Application No: LU/151/21/PL
Site Address: 25 River Road Littlehampton BN17 5BZ
Description of works: Demolition of existing car garage and the erection of 2 no. two-storey residential buildings comprising 5 no. flats with associated works. This site affects the character & appearance of the Littlehampton River Road Conservation Area & is in CIL Zone 4 (Zero Rated) as flats.

Thank you for your internet representation made on 15th June 2021 which has been recorded as an objection with the comments as follows:

OWPC37446

TA 1235 / 11

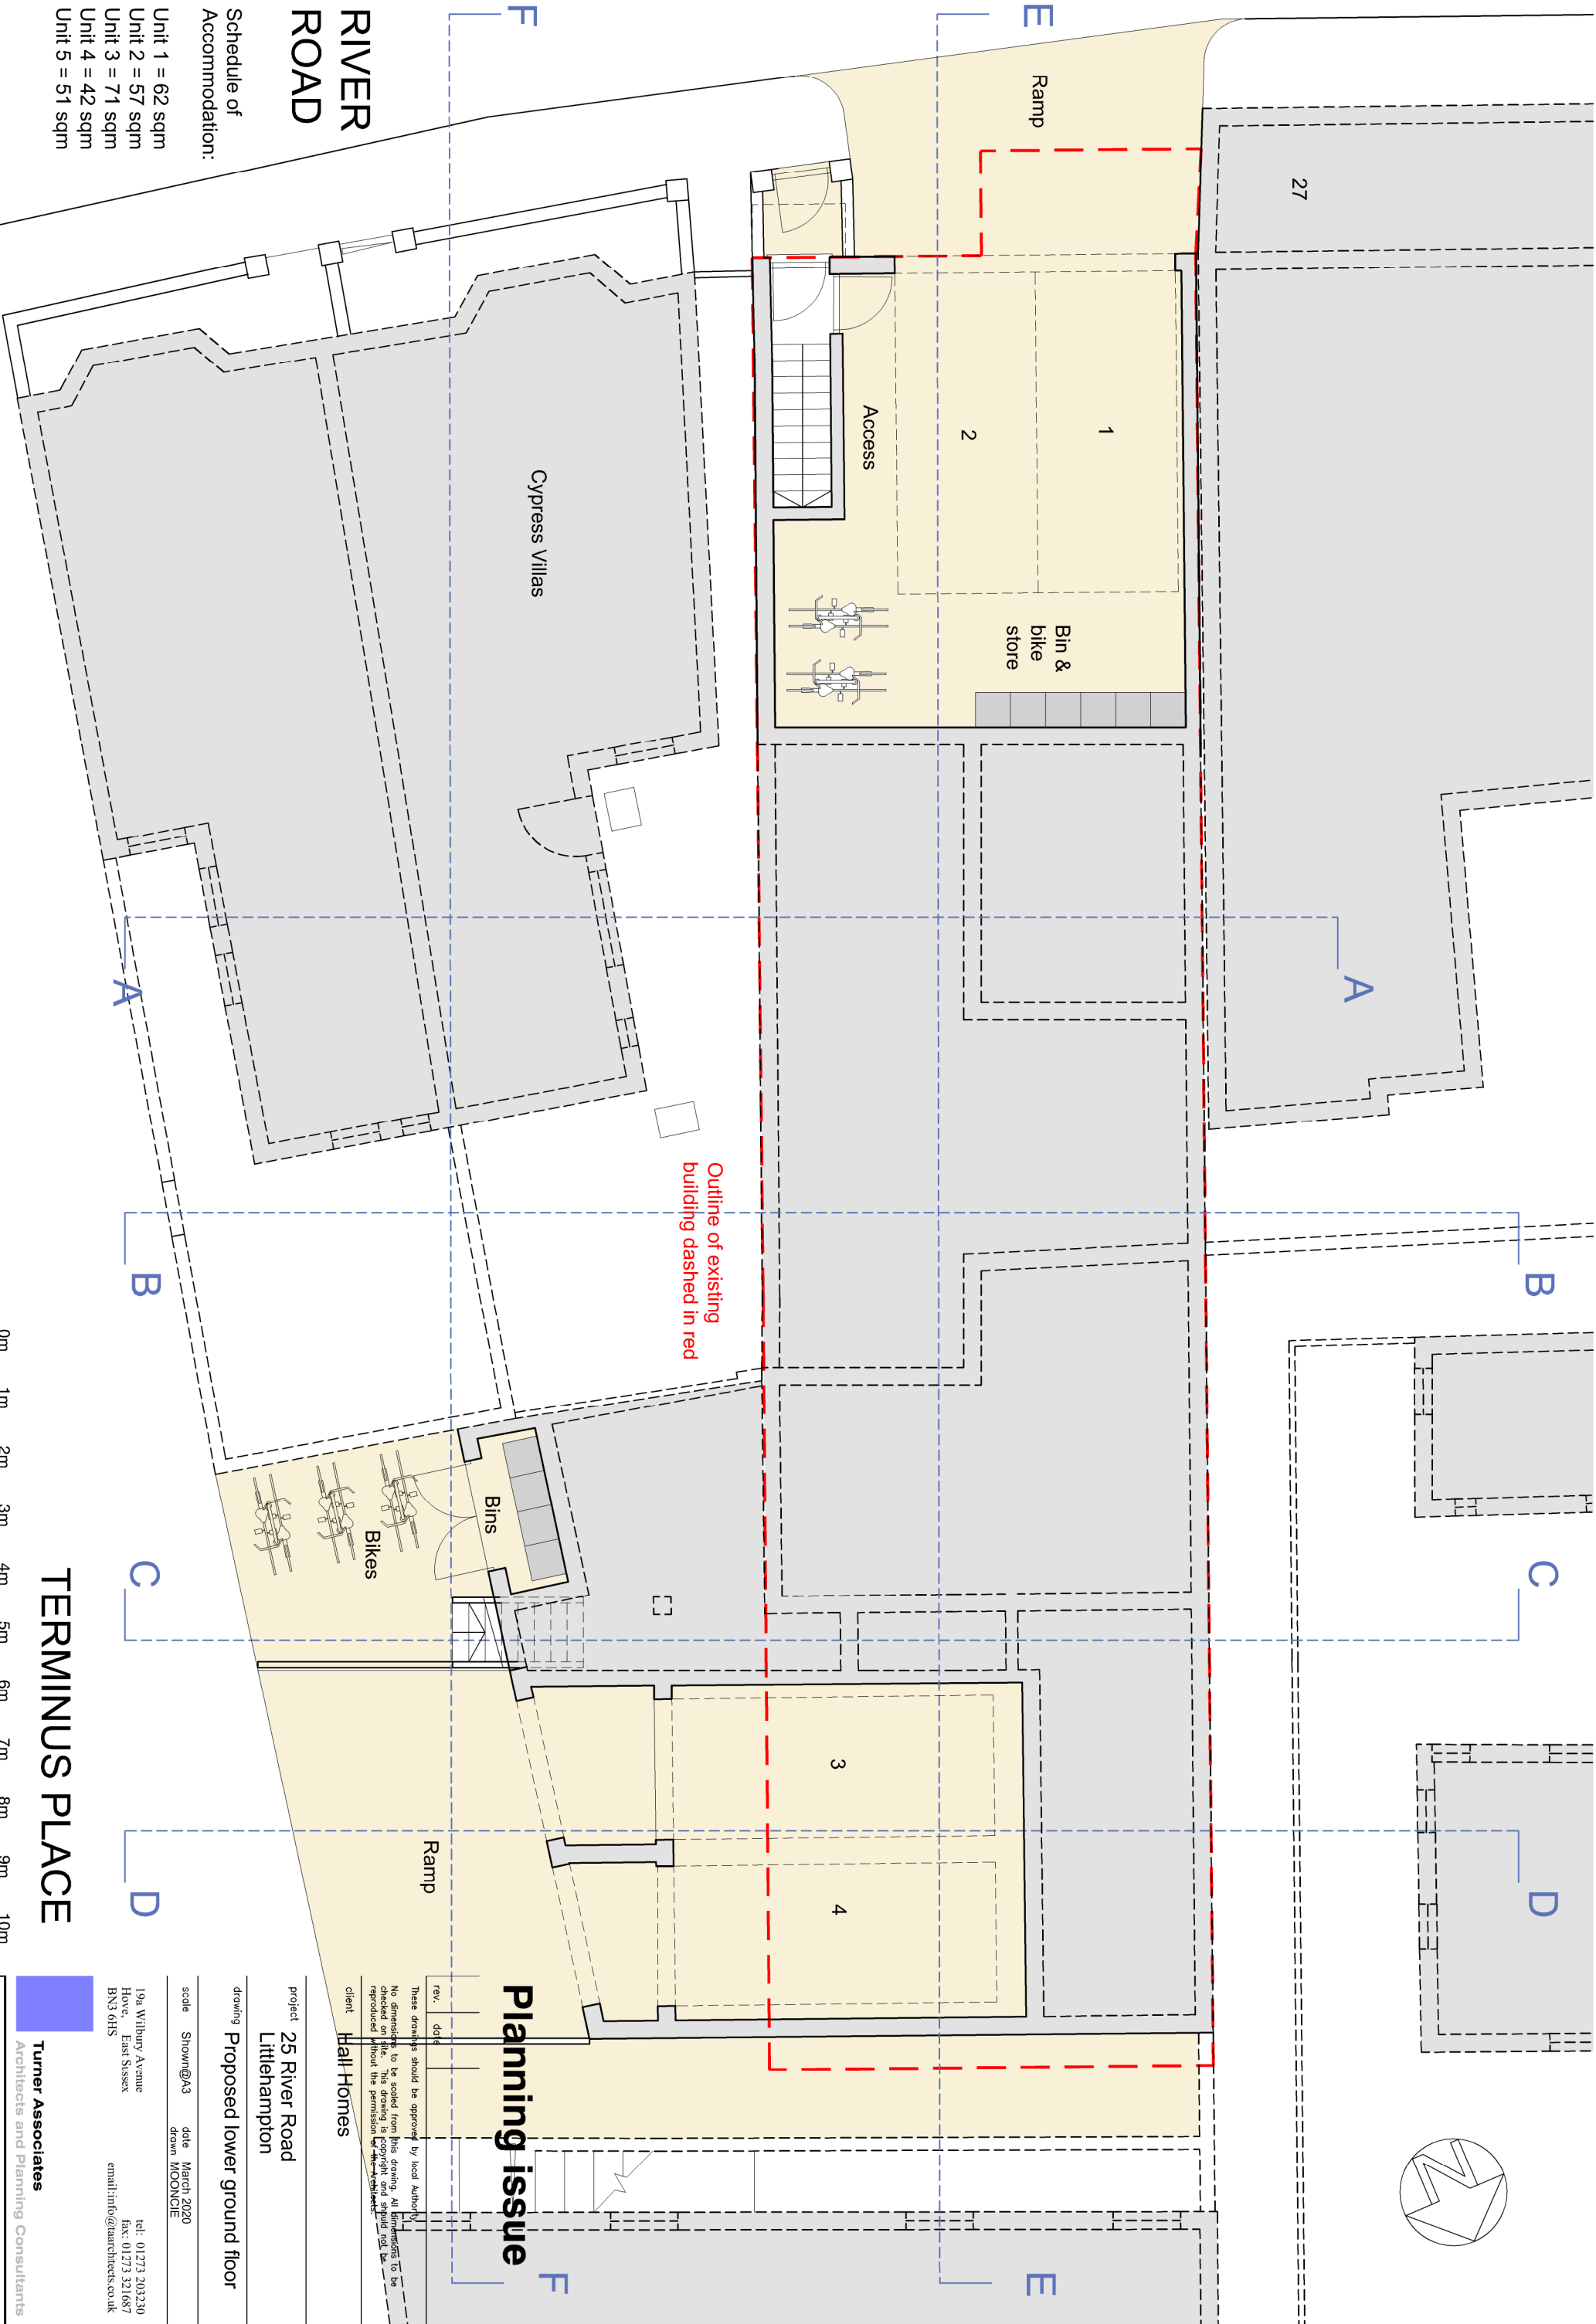
2, TA 1235 /14 shows the space for the underground parking as mentioned in your forward ,

This has raised the height of the build and whilst the angle to our third floor window shows at 25 degrees - the additional height will reduce the amount of late sunlight we currently enjoy through that window as the sun sets

It is too high due to the parking excavation.

TA 1235 / 13

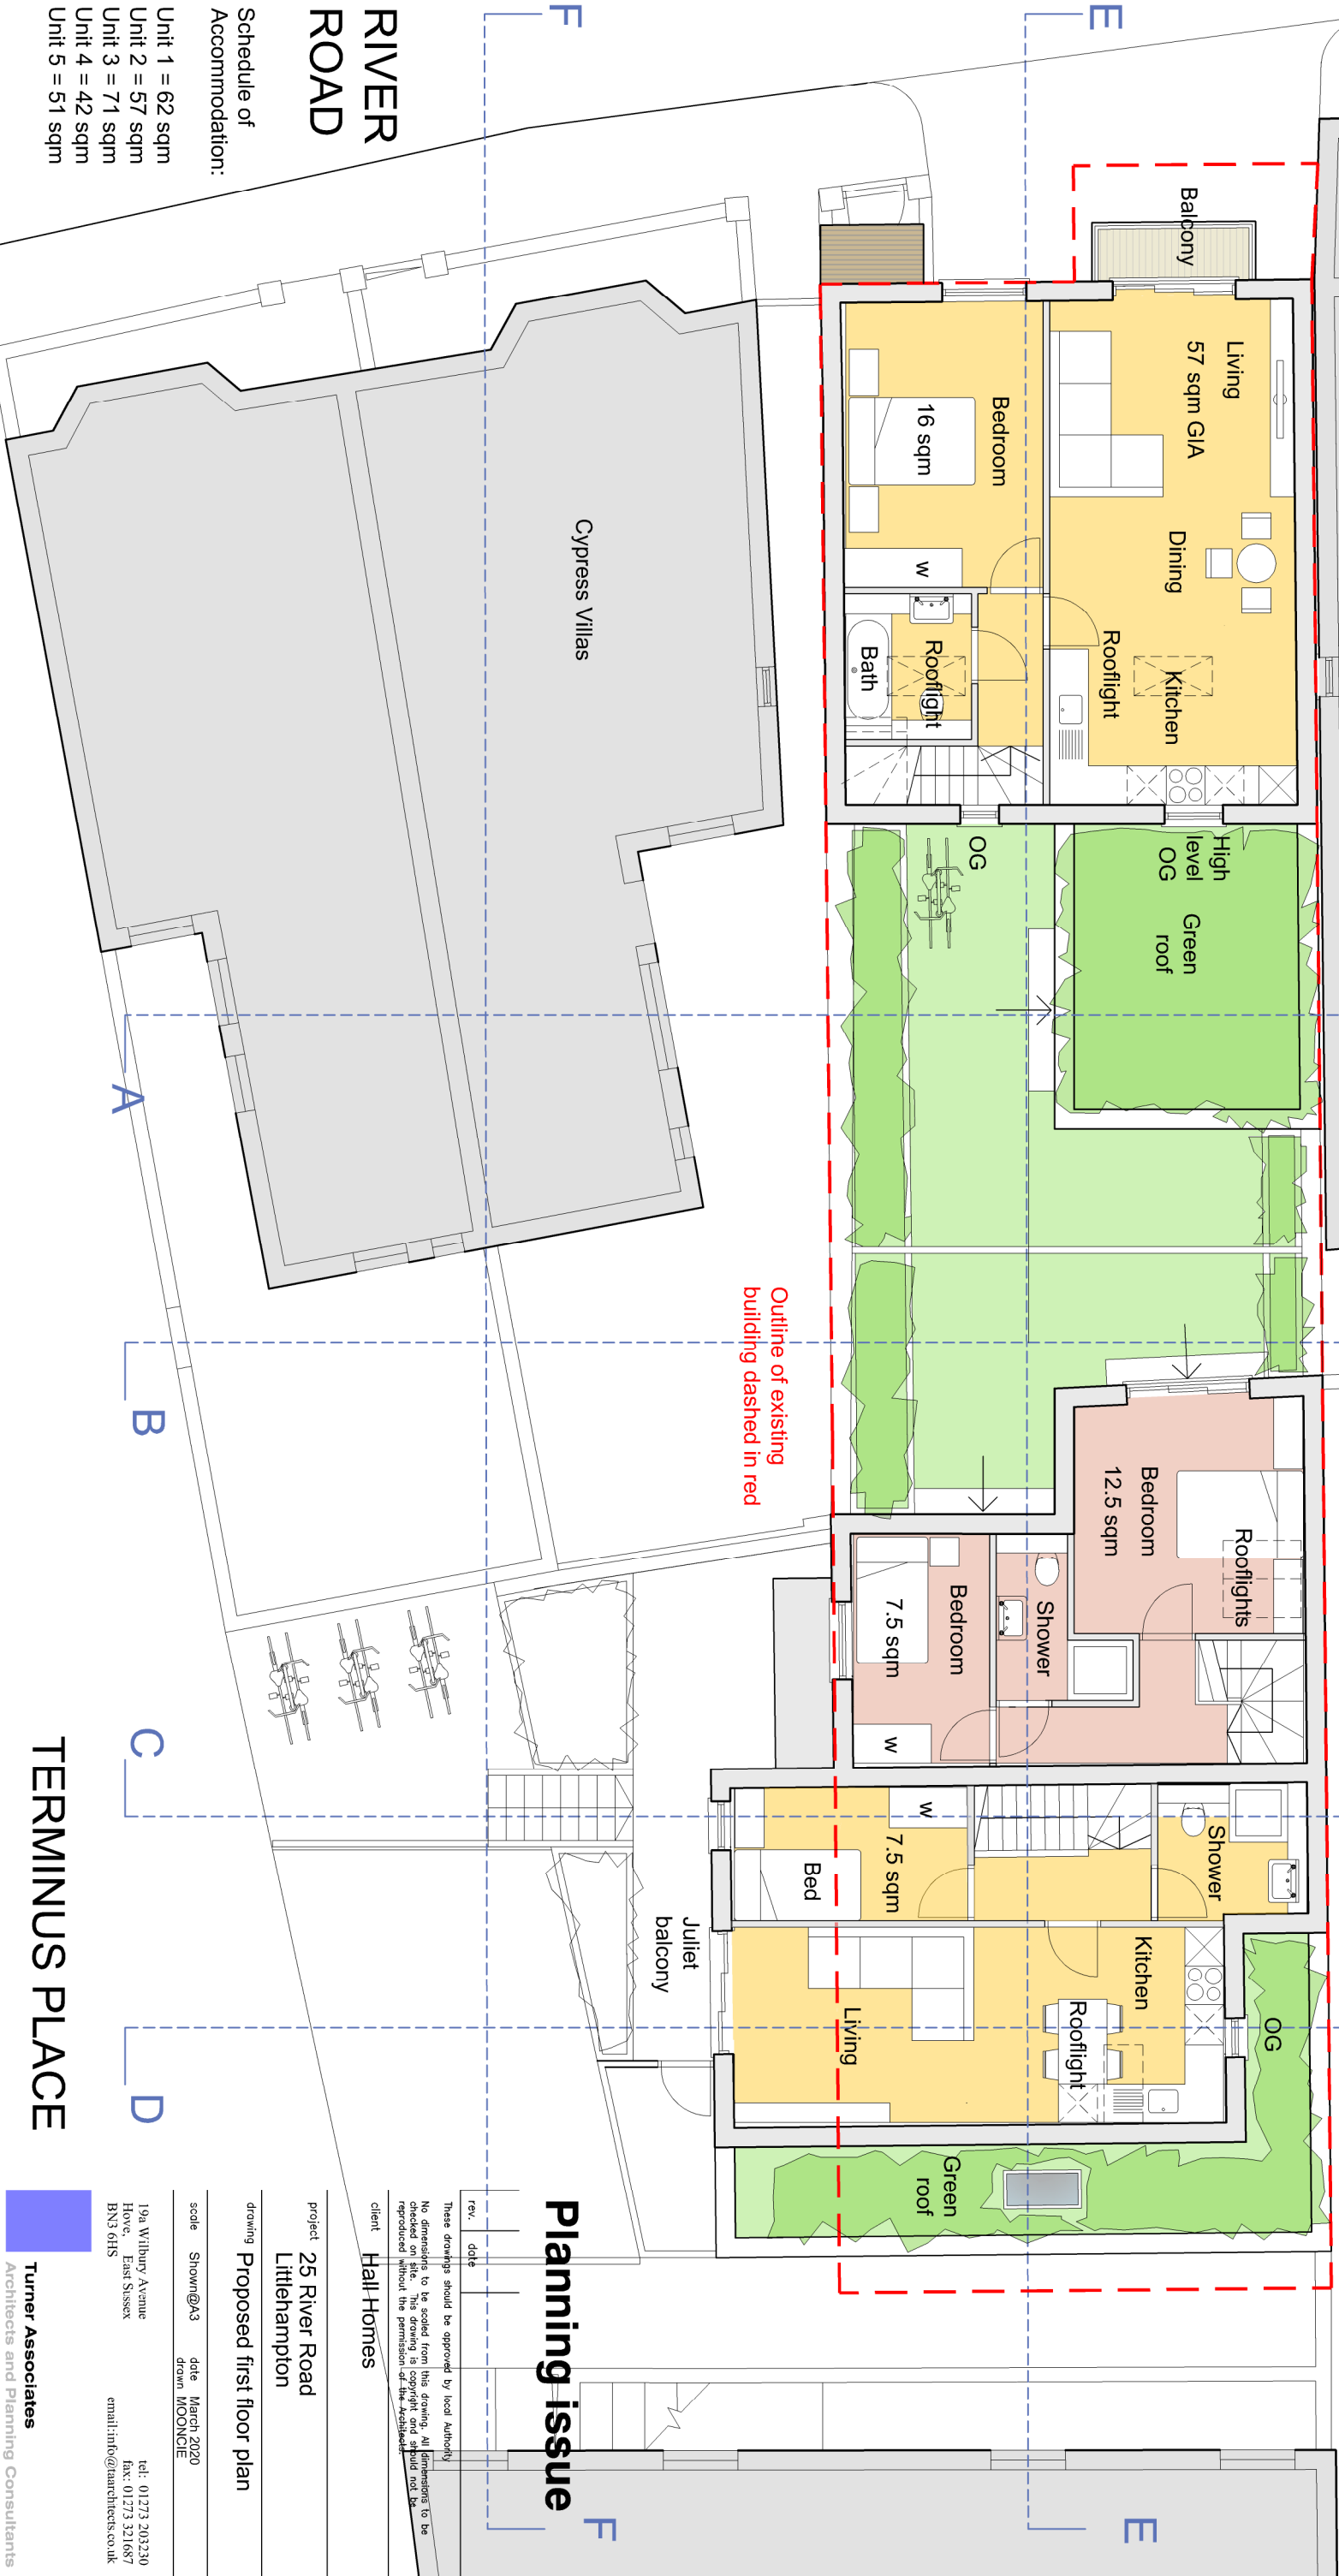
6. TA 1235 /10 -TA 1235 / 15 and TA 1235 / 13 and TA 1235 /23- Green Roof space -

A - What access is being provided to this space

B - Whilst it is set back from the joining wall - will they be able to look into our garden?

TA 1235 / 18

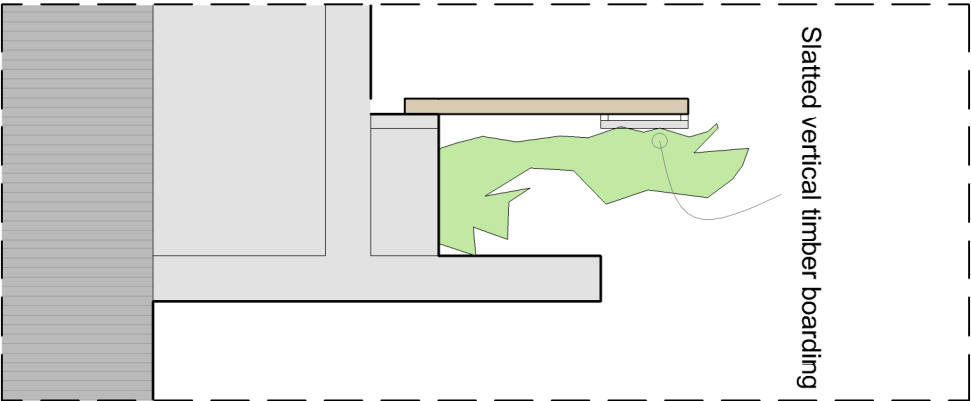
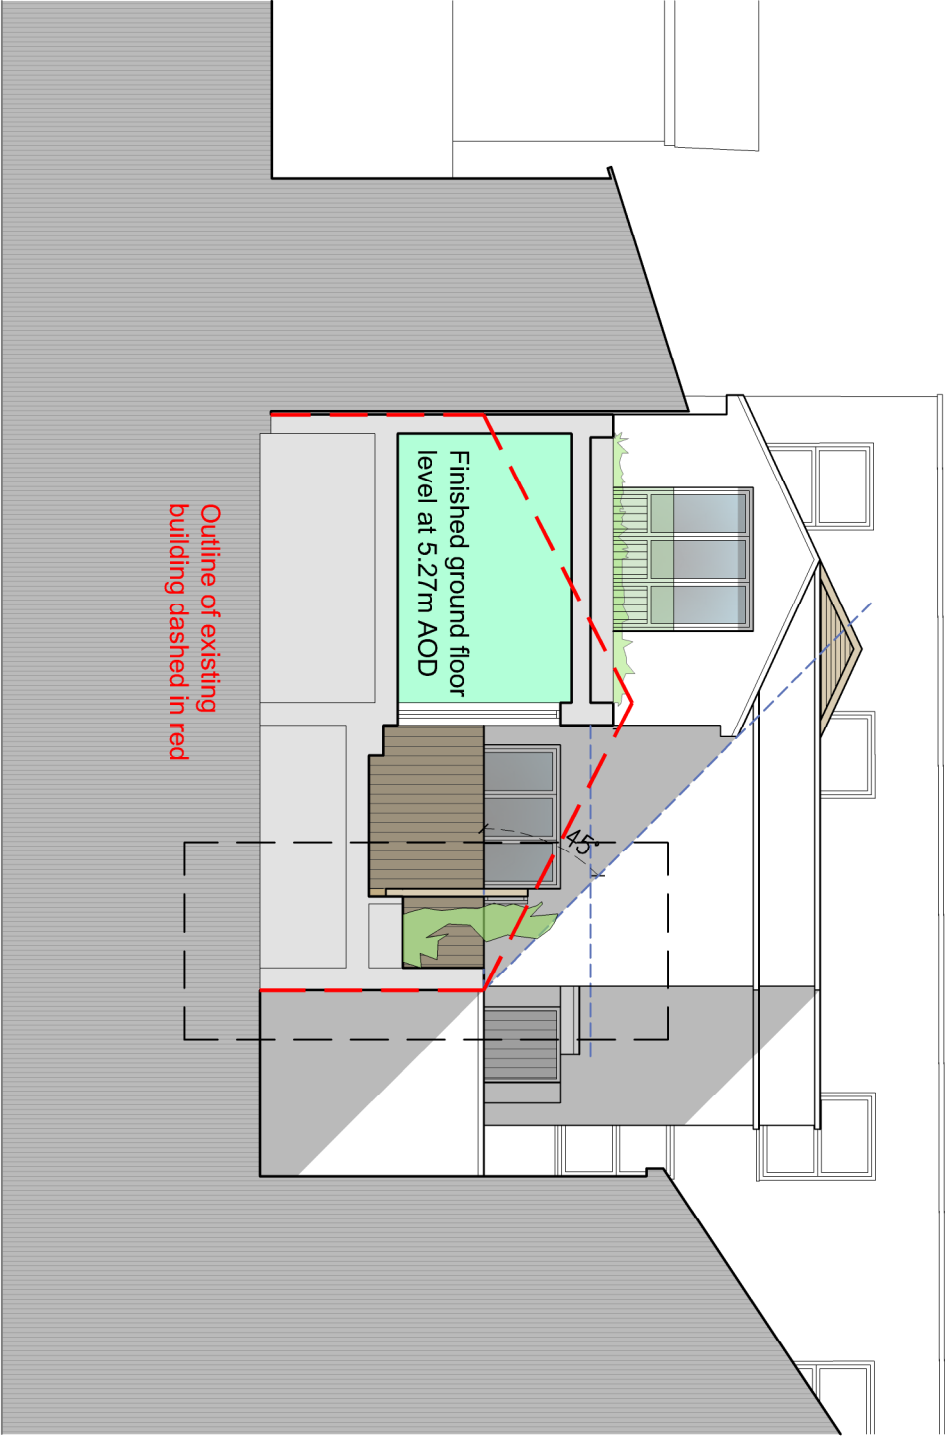
7. TA 1235 / 18 cross section at line AA

A .please clarify the view point? is this showing a cross section at AA, facing South or North ?

B. If South - aspect of drawing is showing items in the North which you would not see

C. If South - the drawing needs to be mirrored so screening is shown on the left (West) and new building right (West) and reflect the roof height at this point.

D. If North - then clarification needed for cross section BB - TA 1235 / 19
